Transport Engineering

REF: N170560

DATE: 4 September 2020

RE: LIVERPOOL HOSPITAL REDEVELOPMENT (SSD-10389) – RESPONSE TO TRANSPORT-RELATED SUBMISSIONS

CAMPUS VISITOR BICYCLE PARKING LOCATIONS

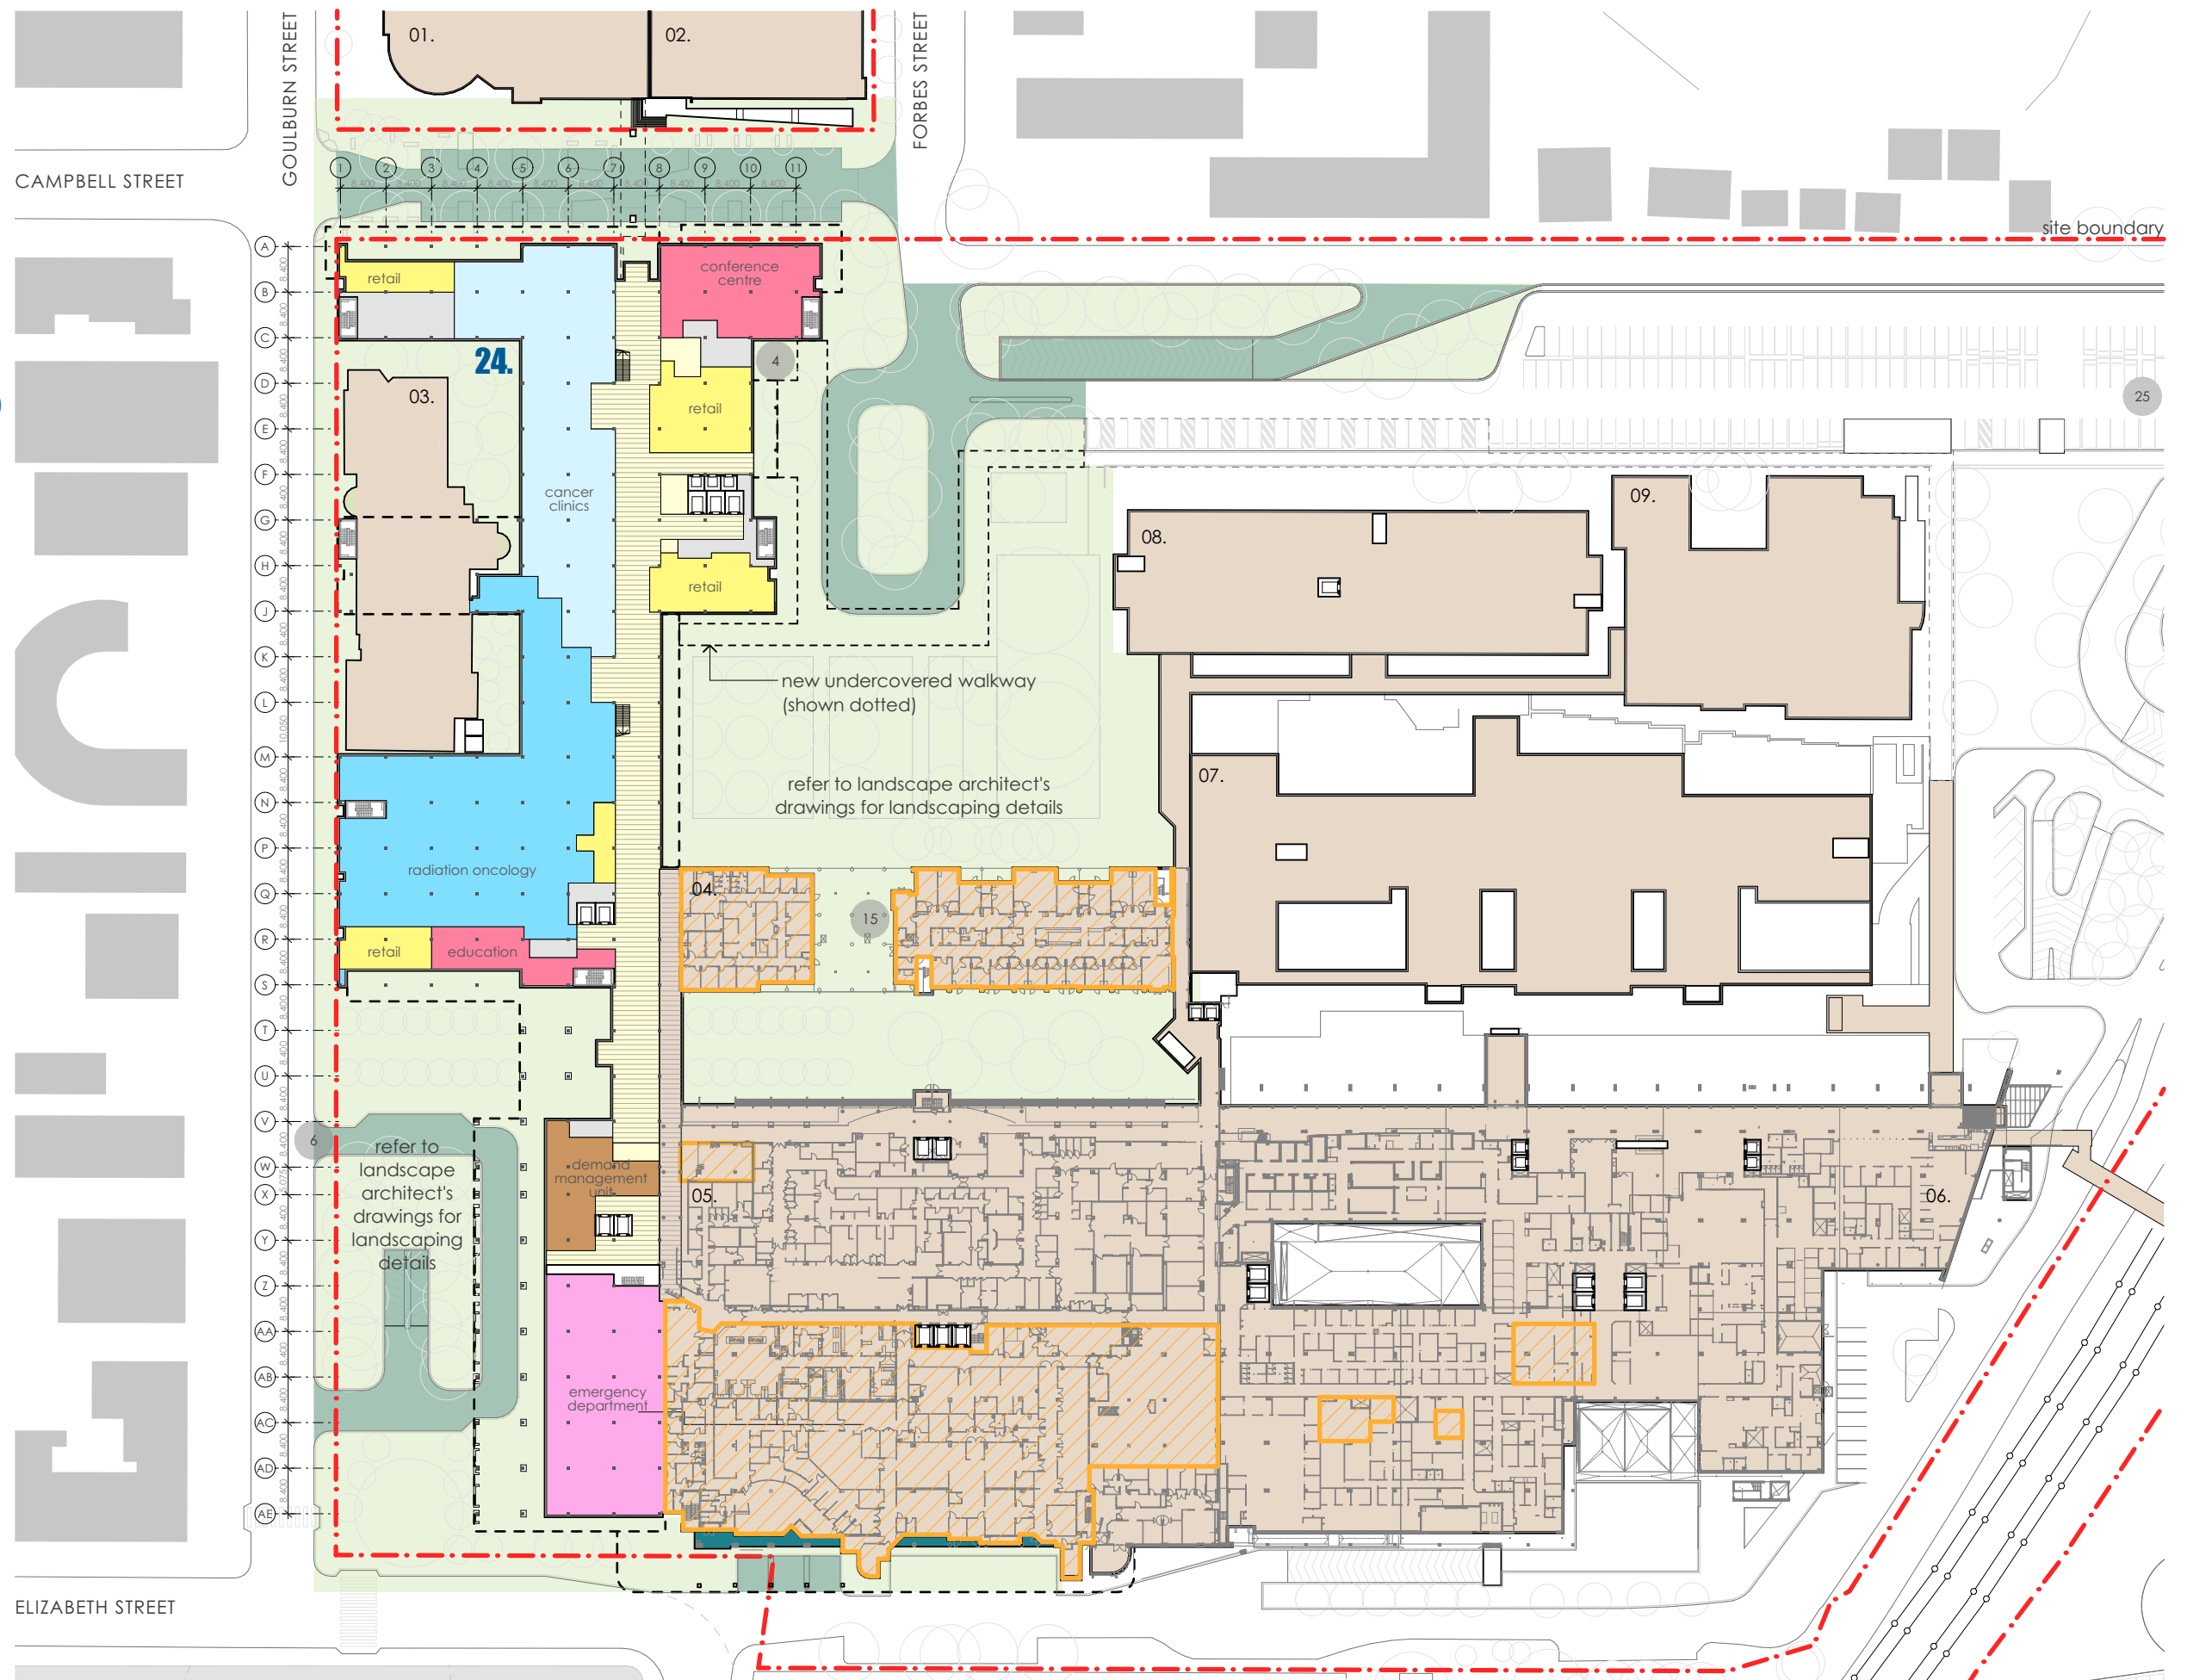
LCC comment: The EIS has noted that bicycle parking would be provided at a bicycle parking rate of five per cent of staff for both staff and visitor provision, due to the hospital's location and limited surrounding cycling infrastructure. Council is working to improve cycling infrastructure in the area, evidenced through the Liverpool Bike Plan 2019-2023 and the Public Domain Masterplan. The Liverpool Collaboration Area Place Strategy and Liverpool Innovation Precinct also indicate the importance of improving cycling infrastructure and rates of cycling in the area.

Noting this, the hospital's role in promoting healthy built environments and in order to assist in enacting the Green Travel Plan (Appendix E), a bicycle parking rate of 10 per cent of staff for both staff and visitor provision is considered more appropriate to meet strategic goals. This would equate to:

- 42 bicycle spaces for staff in the basement of the CP1 car park

- 42 spaces for visitors in the public domain.

GTA response: The future vision for the CBD and bicycle infrastructure in the area is recognised. It is proposed to increase bicycle parking provision, in accordance with Council's suggestion, to the following:

- A minimum of 50 secure staff bicycle parking spaces the P1 basement car park
- A minimum of 25 visitor bicycle parking spaces throughout the new public domain areas
- A minimum of 25 visitor bicycle parking spaces in the new MSCP.

Plans showing the proposed bicycle parking in the P1 basement car park are included in Attachment 3, while the other bicycle parking areas are shown on the updated architectural plans and landscape plans.
